**APPLICATION BY NATIONAL HIGHWAYS FOR AN ORDER GRANTING  
DEVELOPMENT CONSENT FOR A57 LINK ROADS PROJECT:**

**DEADLINE 11 (11TH MAY 2022) ENVIRONMENT AGENCY COMMENTARY &  
WRITTEN RESPONSE TO:**

**Appendix 2 – Technical Comments and Review of Deadline 3: [REP3-025]  
[9.43 Environmental Statement] Appendix 13.2; Hydrology Risk  
Assessment dated January 2022**

**6.3 Environmental Statement  
Fig 9.1 Geology and Soils Figures**

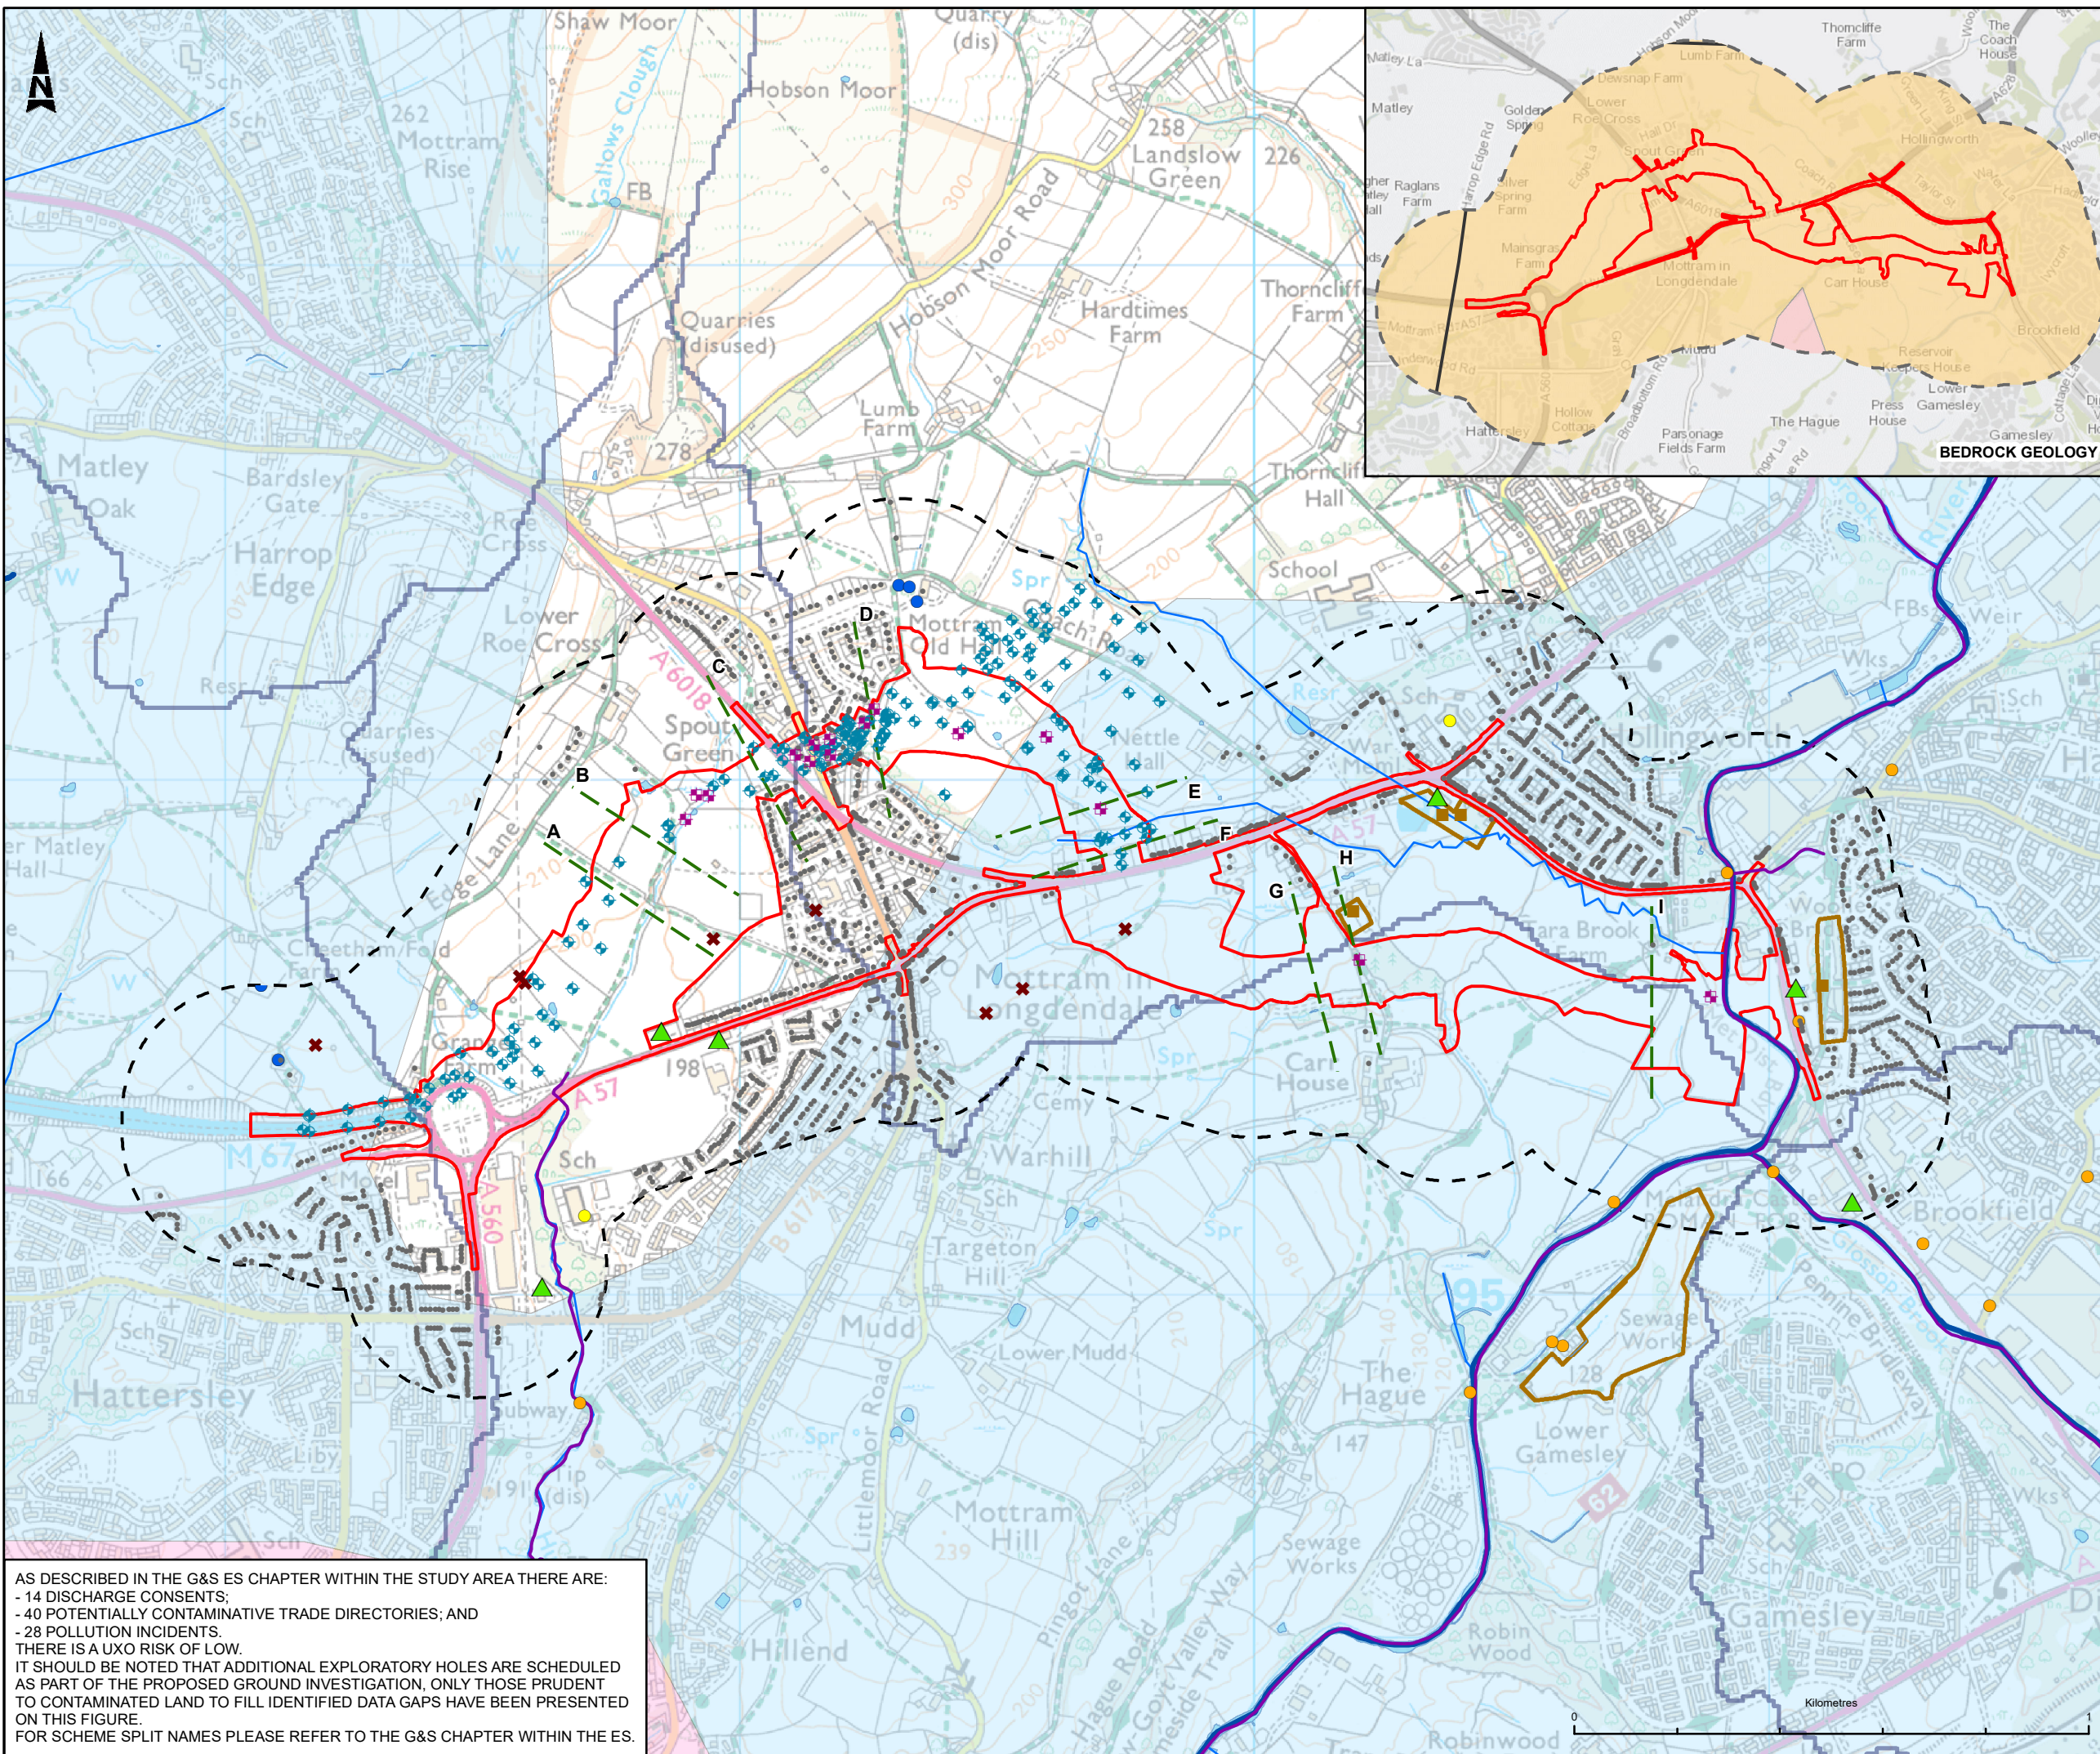
The location of these within the study area is shown on Figure 9.1.

The closest abstraction is located at Mottram Old Hall, approximately 75m of the closest red line boundary.

According to the Environment Agency's Approach to Groundwater Protection, "*All abstractions, including private water supplies, that are used for drinking water supply or food production purposes are by default in an SPZ1 or SPZ2.*".

On Figure 9.1 of the HRA there needs to be a list of spring, surface and groundwater abstractions and surface water features found within the study area. These features also require a unique national grid reference number.
